Planning Application Ref: **AW/198/18/PL**

Location: **Land Between 8 And 12 Wychwood Close, Aldwick, PO21 4DW**

Description of works: **Erection of 1 No. 4 bed dwelling, formation of new access & felling of 4 No. trees to the rear of the site. This application affects the character & appearance of the Craigweil House Conservation Area**

Tree Officer / Parks and Greenspace Team

TREE PROTECTION PLAN

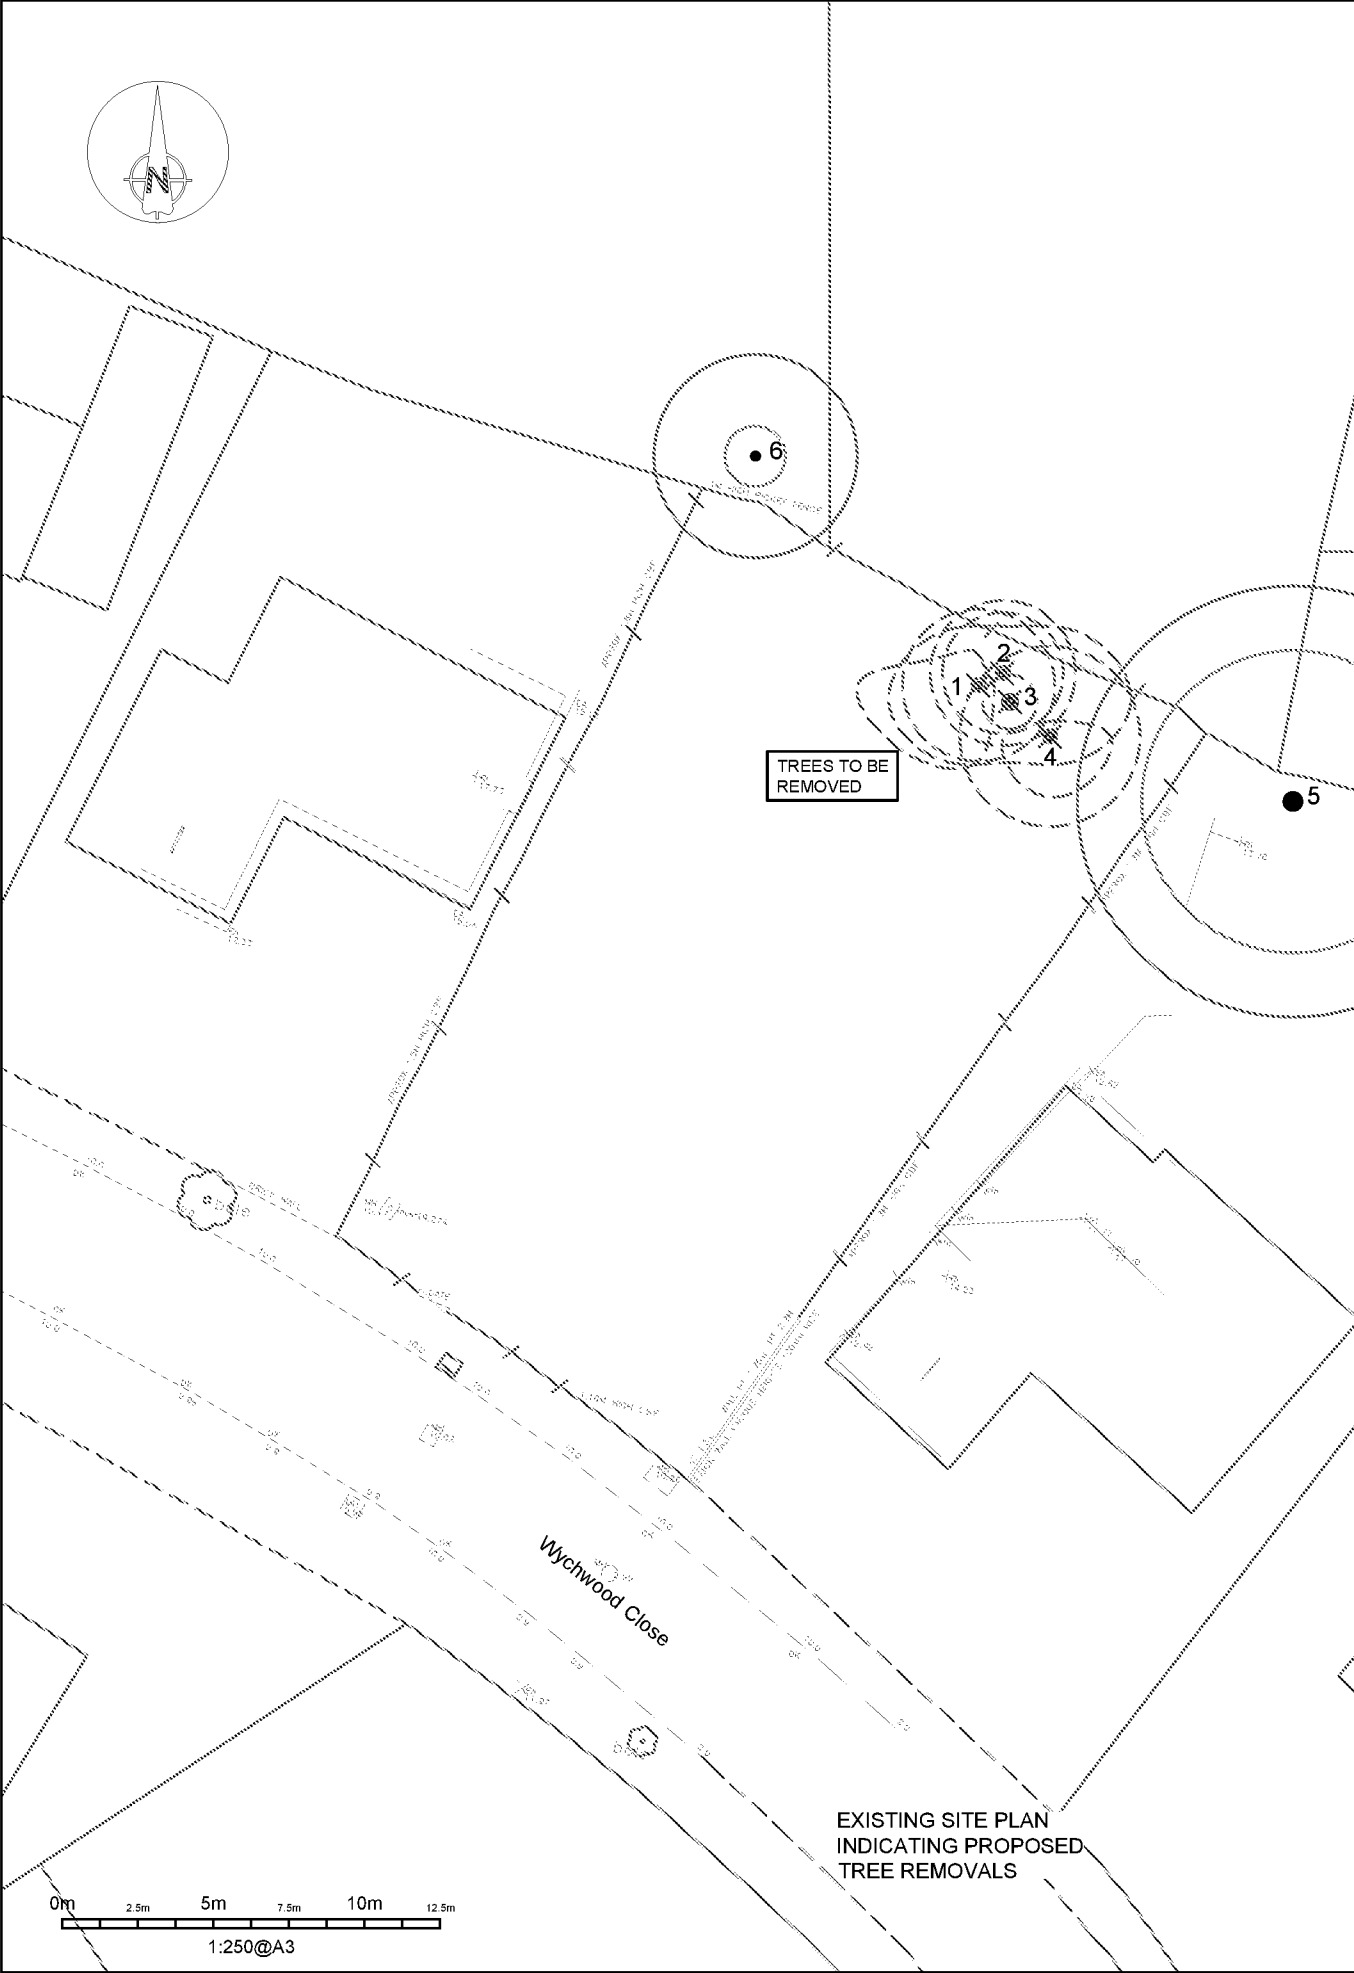
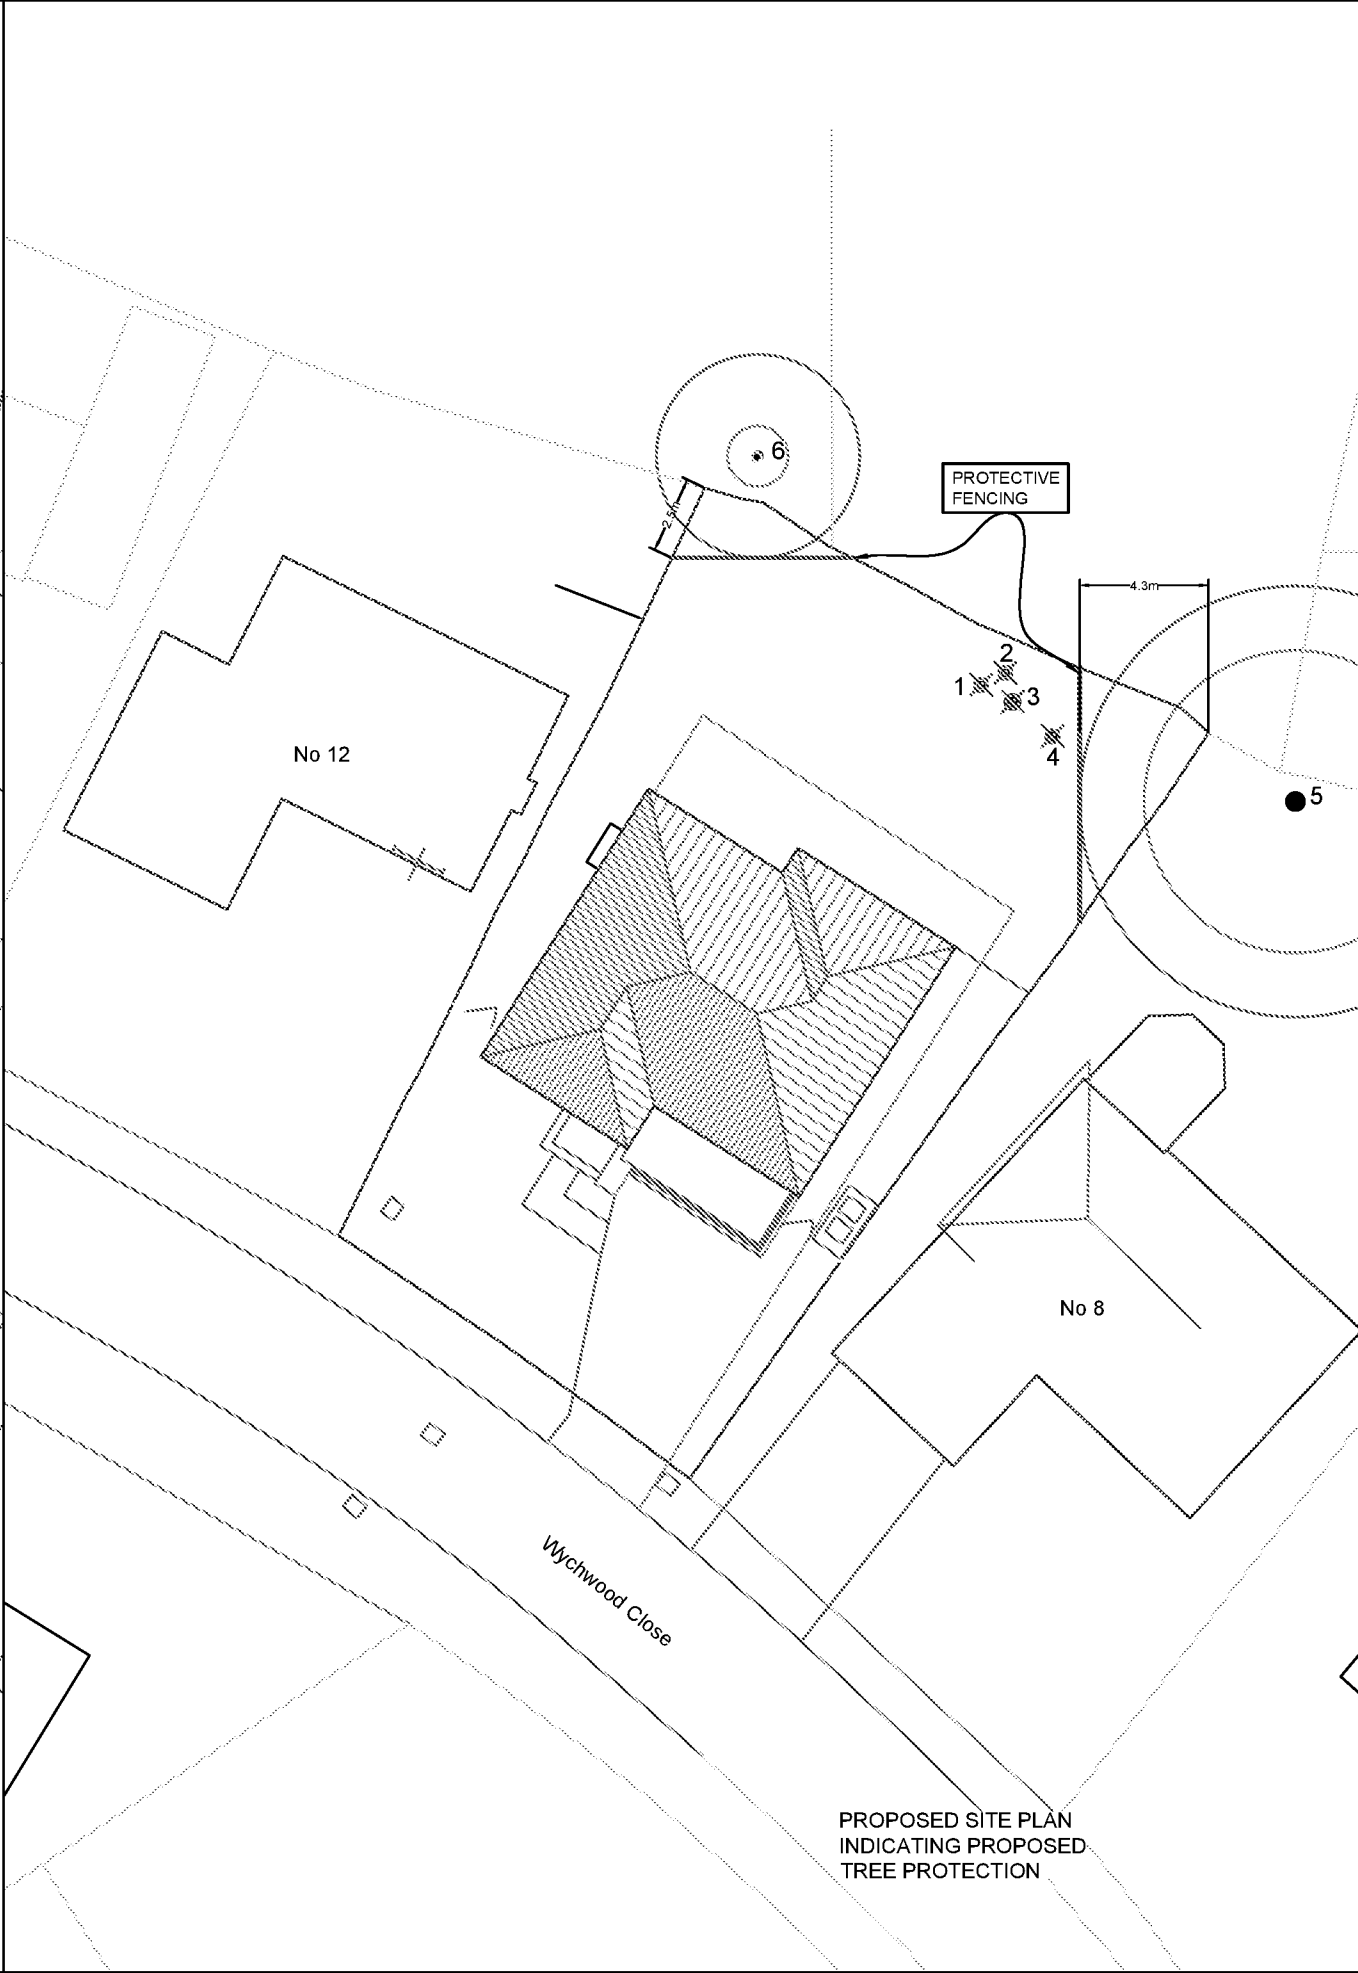
- The applicant has employed David Archer Associates to submit a Tree Schedule and Tree Protection Plan (TPP), dated 16th March 2017 and June 2018 respectively. The Tree Survey data is adequate and broadly accords with the requirements of BS5837:2012. For the record, I have calculated (and the above TPP demonstrates) root protection areas and expect those to inform the position of tree protection fencing on site, as follows: T5-7.1m, T6-3.4m.

- There is a cluster of even-aged on-site trees to the rear of the proposed dwelling (T1-T4), all of which could be successfully retained but have been identified for removal. They are not of particular merit and whilst unfortunate, their removal would not adversely affect the character of the area.

- The prominent tree of value is T5 (recorded as T99 on TPO/AW/228/10) an off-site oak, which has been afforded adequate protection in principle, as has T6 an off-site beech.

- I recommend **APPROVAL** for this application, subject to the following conditions being applied:
 - Before the site is occupied or any machinery is introduced to the site or demolition work or construction work or alterations to existing ground levels takes place, the Arun DC Tree Officer must have the opportunity to inspect all protective fencing to verify it is 'Fit for Purpose' as required under British Standard 5837:2012 and have been erected and positioned exactly as shown/described on the **Tree Protection Plan, dwg.no. TPP 01, dated June 2018.**
 - If there is deemed to be a need for any Utility Service Route connections to bisect retained tree Root Protection Areas/Zones then prior to their installation a Method Statement prepared by an Arboricultural Expert must be

submitted that stipulates how this can be achieved without adverse impact on tree roots. Written approval and confirmation of acceptance of this Methodology must be issued before any works are commenced out on site.
